Application no: H06/1220/99

Applicant: S E King Building Contractor
192 Bridge Farm
New Road
Sutton Bridge
Spalding Lincs PE12 9QE
Description: Erection of chalet bungalow
and garage

Location: Plot adj. Chapel House
Main Street
Gedney Dyke
Spalding Lincs

ACKNOWLEDGEMENT OF AMENDMENT

Date: January 2000
Scale: 1:250
Drawn: Peter S Lithgow MCIQB MBIAT
Org No: 99/34/02

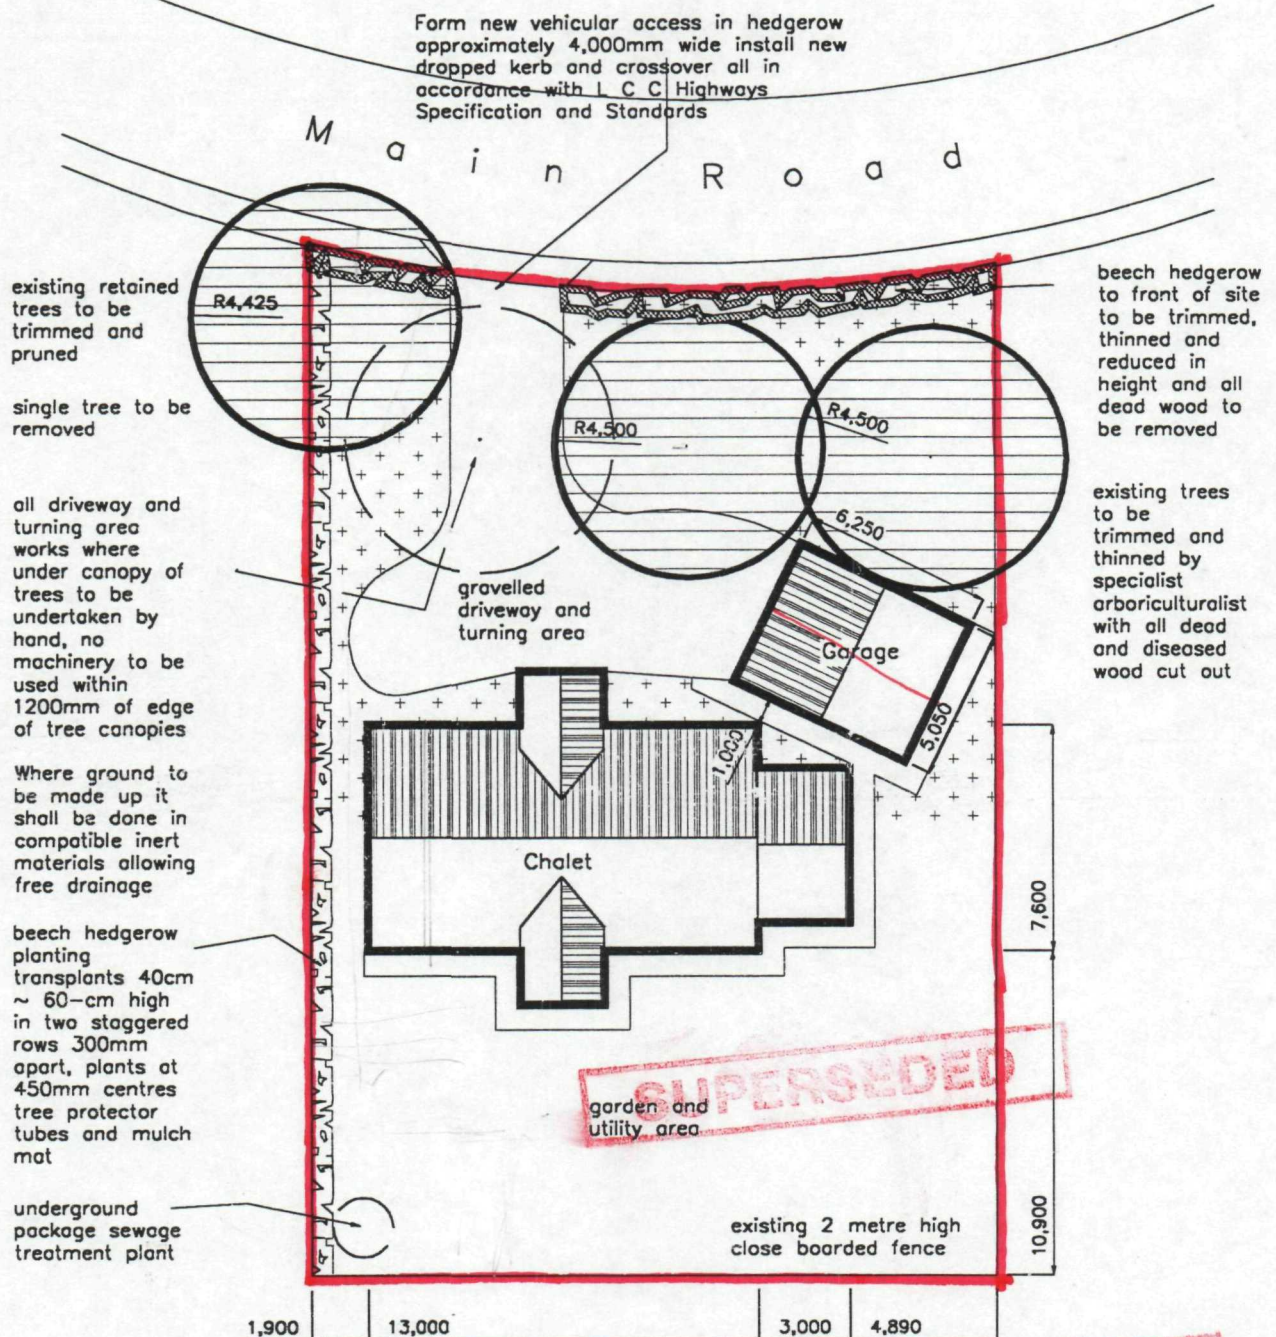
Amendment: Garage moved away from tree line. Three trees retained.
Chalet bungalow relocated.(Dwg no. 99/34/02)

GARAGE MOVED AWAY FROM
TREE LINE.
3 TREES RETAINED.
CHALET BUNGALOW
RELOCATED.

Ground Floor and First Floor Plans Elevations and Block Plan

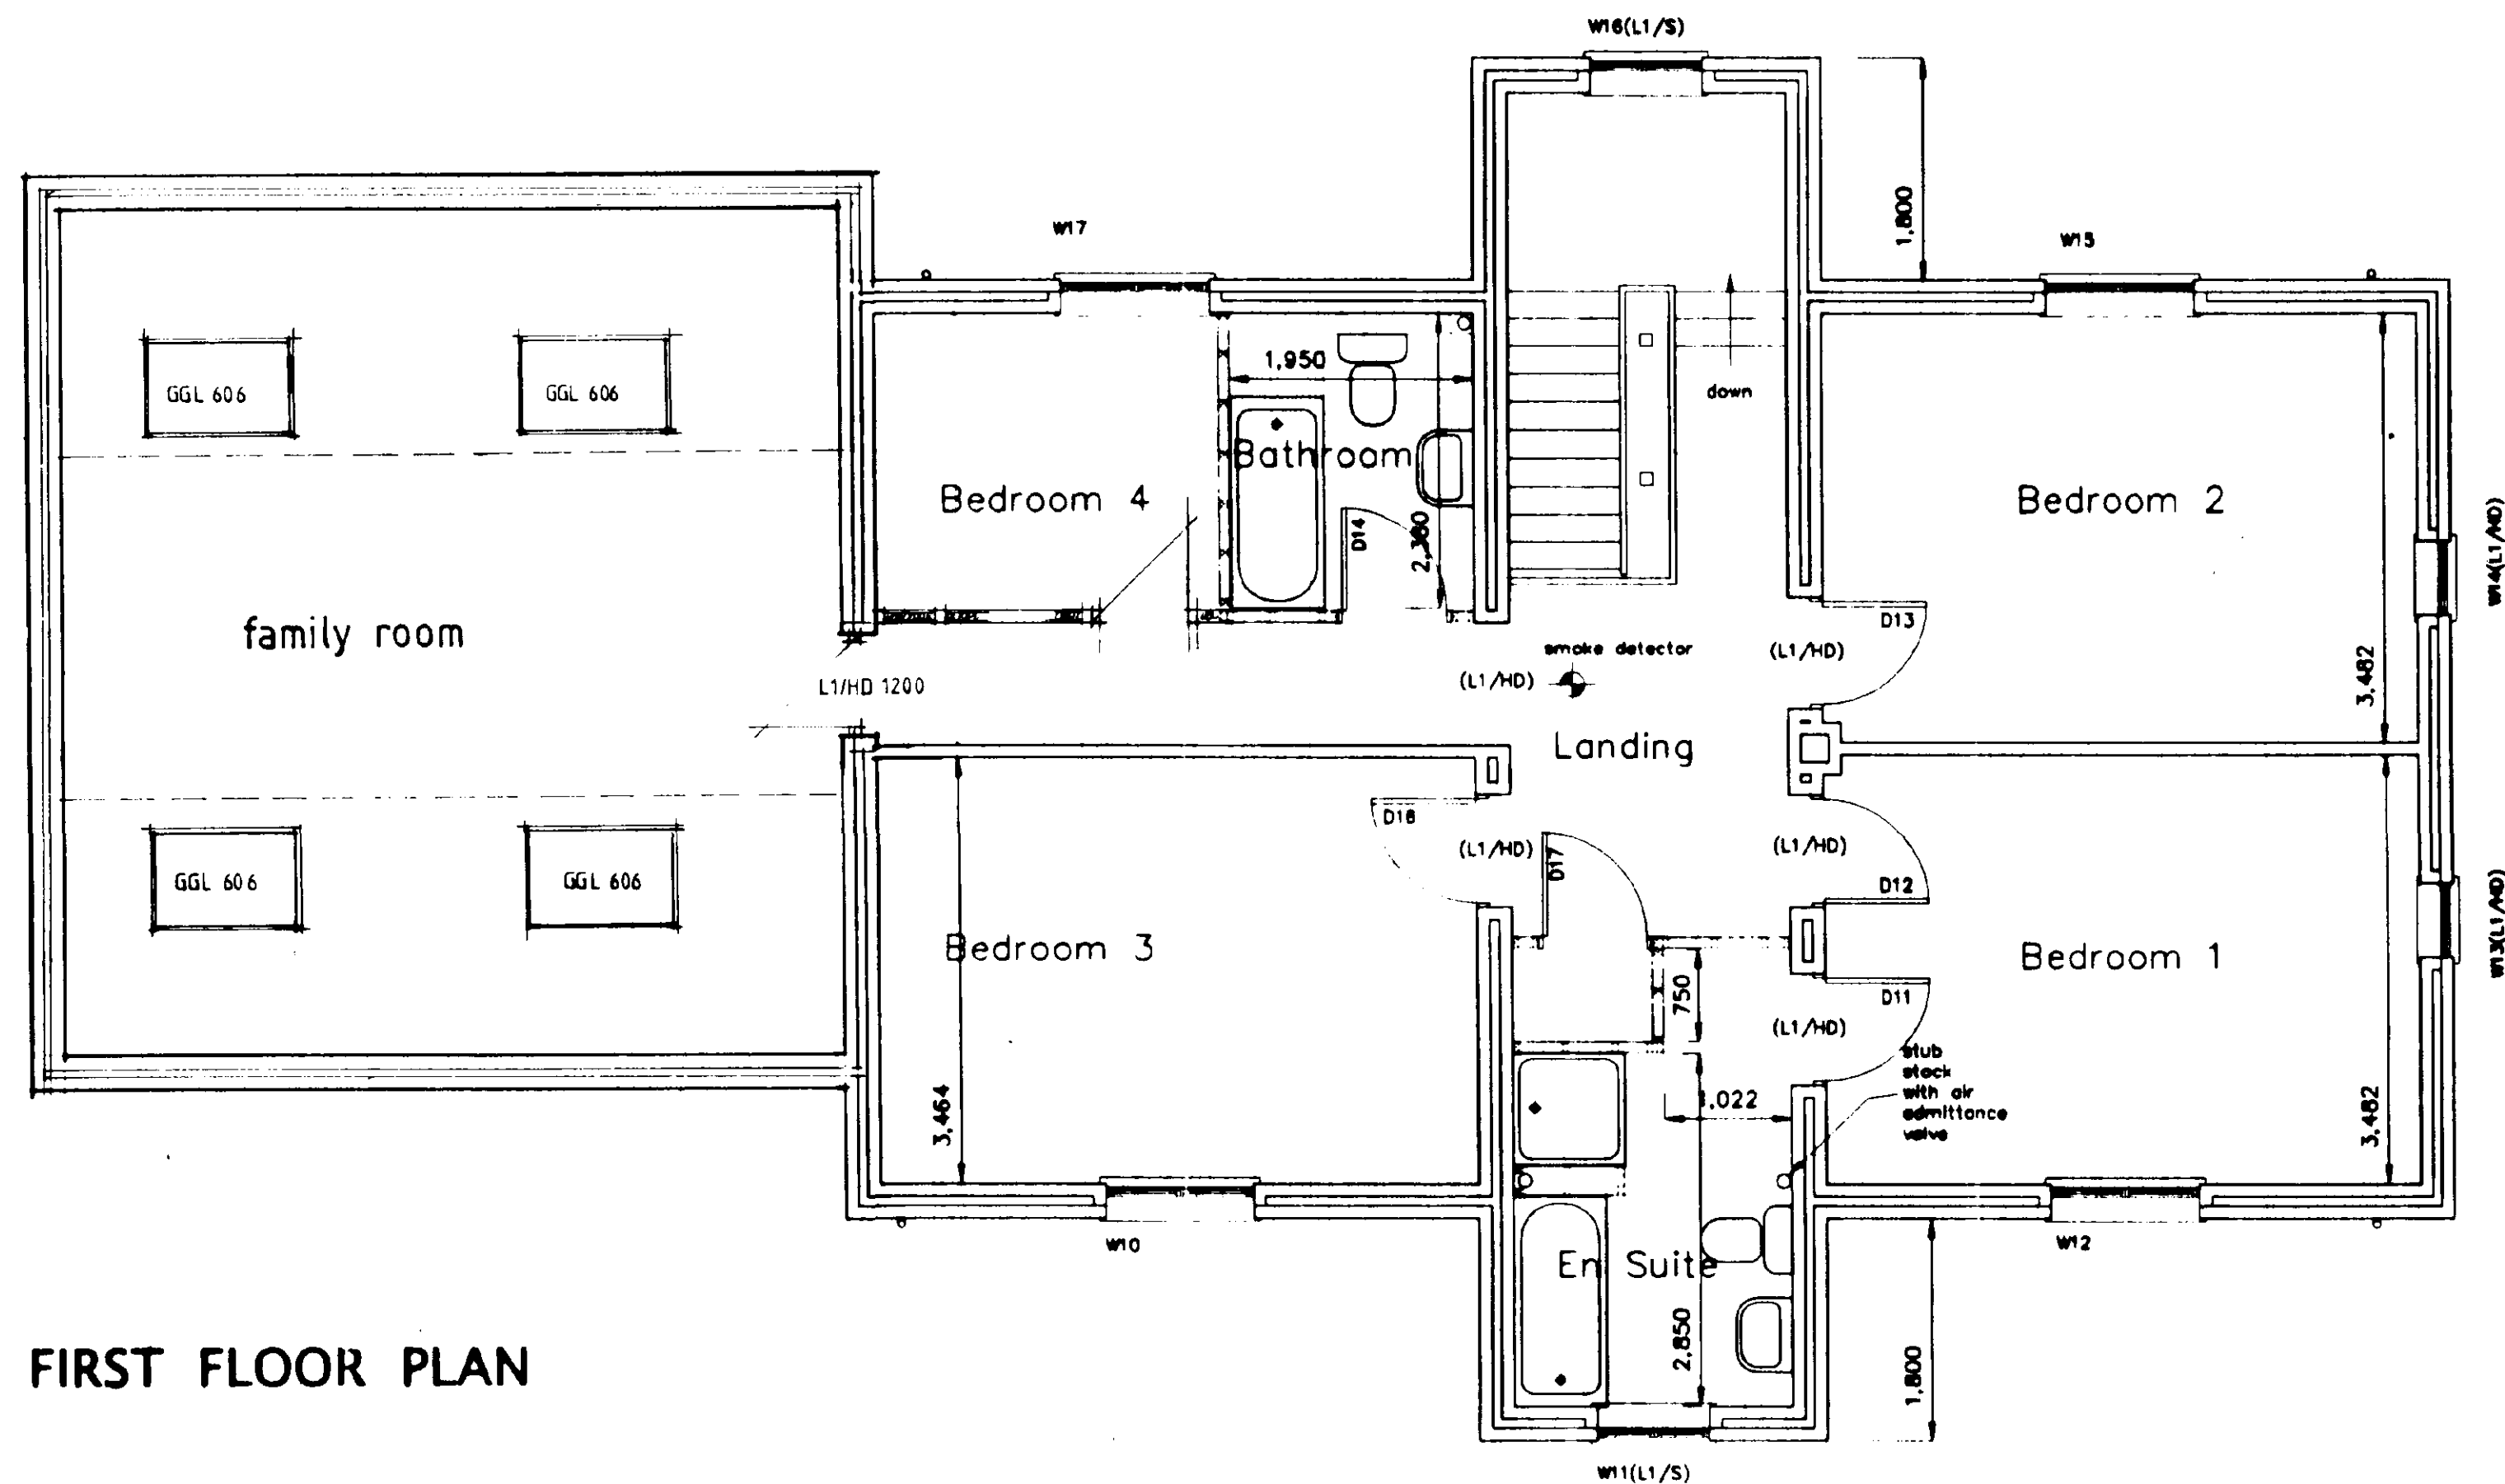
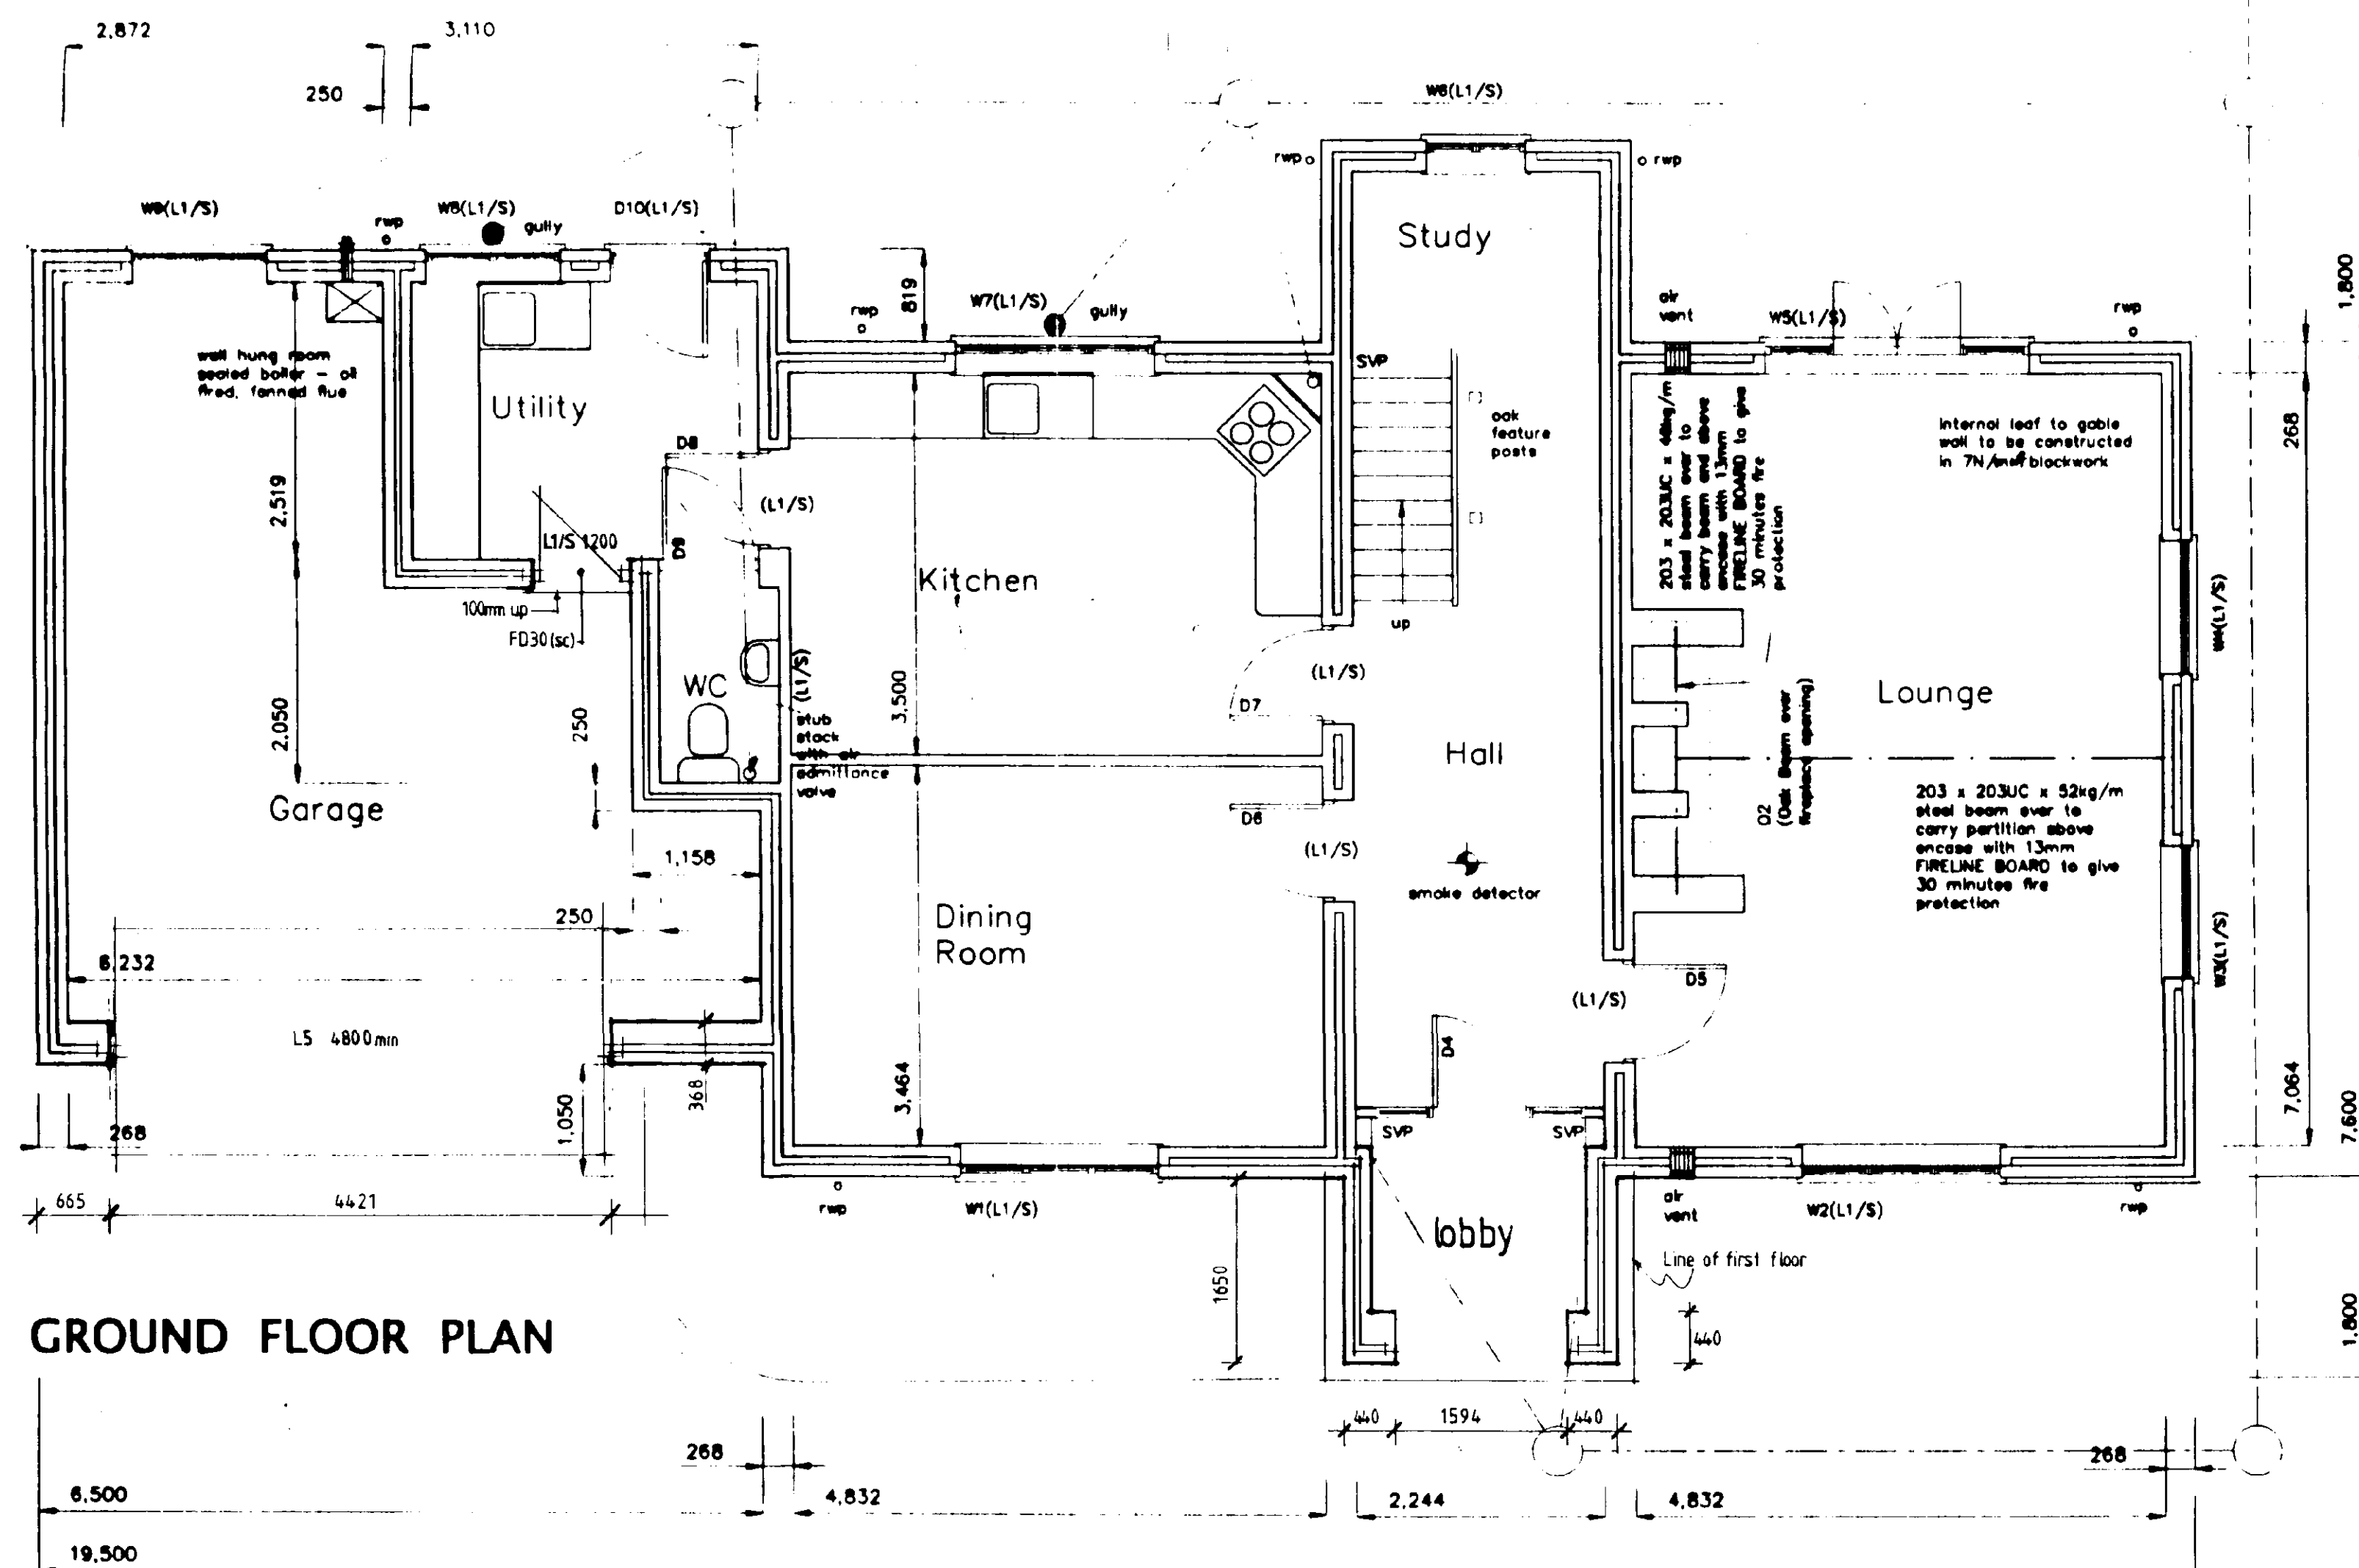
Amendment: Room over garage and roof lights added. Alterations
to front lobby area and garage door. (dwg no. 05D)

ROOM INCORPORATED OVER GARAGE,
ROOF LIGHTS PROPOSED TO FRONT & REAR
MINOR ALTERATIONS TO FRONT PROJECTION
(LOBBY AREA).
GARAGE DOOR REUSED.

The amended details submitted in respect of the above proposal have been received and I consider that the changes are too significant to be treated merely as a amendment. A fresh application will therefore be required (forms enclosed). This does not imply that premission will or will not be forthcoming for any such revised application.
